Application for non-material amendment following a grant of planning permission

Partial removal of existing ground floor garage roof. Removal of existing conservatory to rear. Construction of double-storey extension over existing conservatory footprint and ground floor garage, to allow for additional bedroom and en suite bathroom to master.

DM/2021/02001

Install a rooflight into the roof above the bathroom, omit the window in the bathroom.

DRAWING NUMBER	REVISION
A220

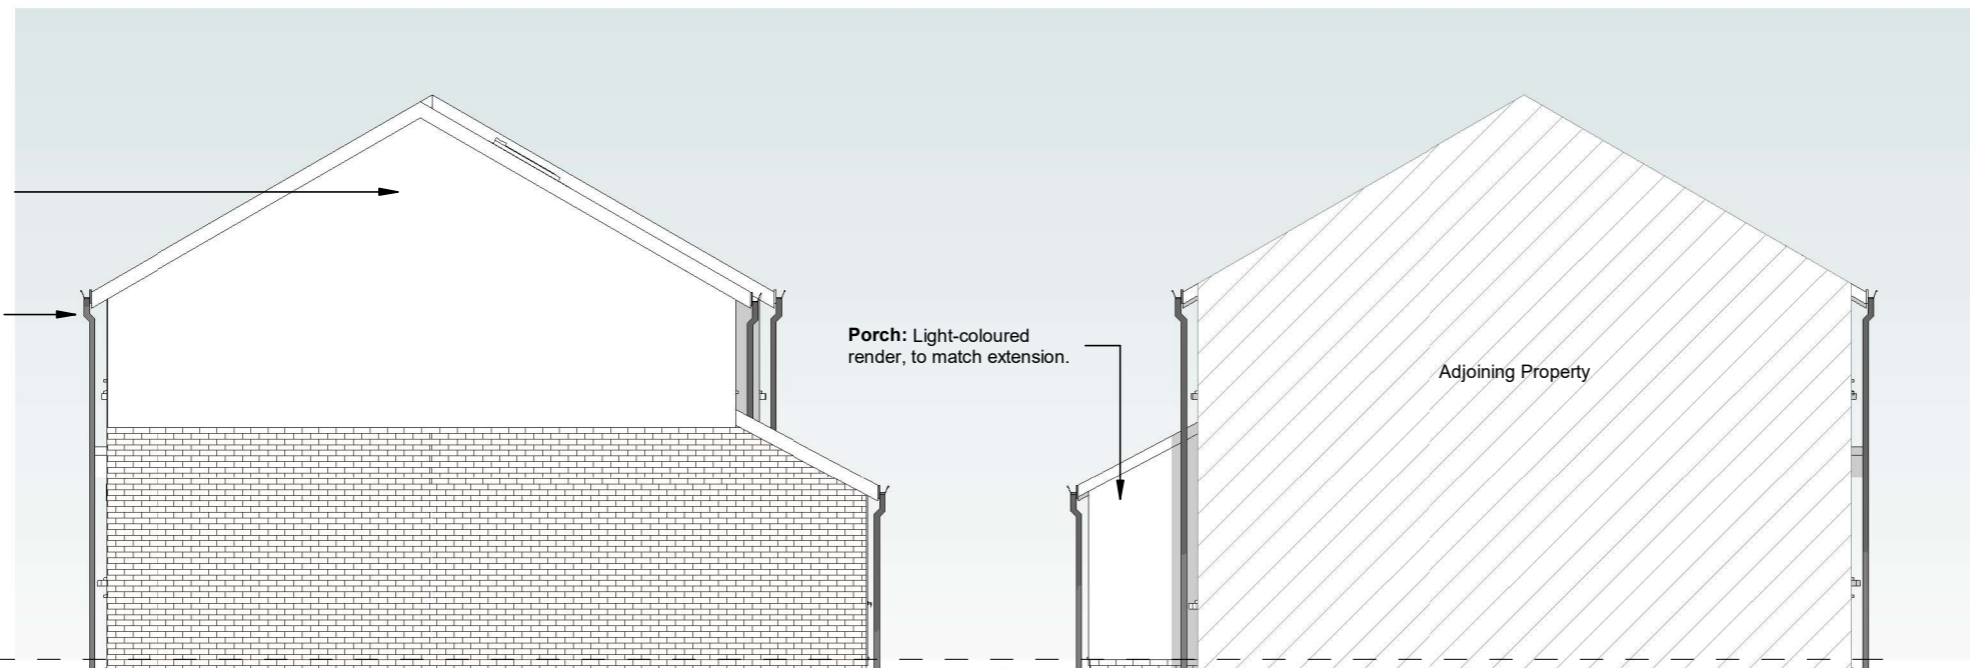
When the works were completed the window had not been installed and the applicant would now like to have a rooflight instead.
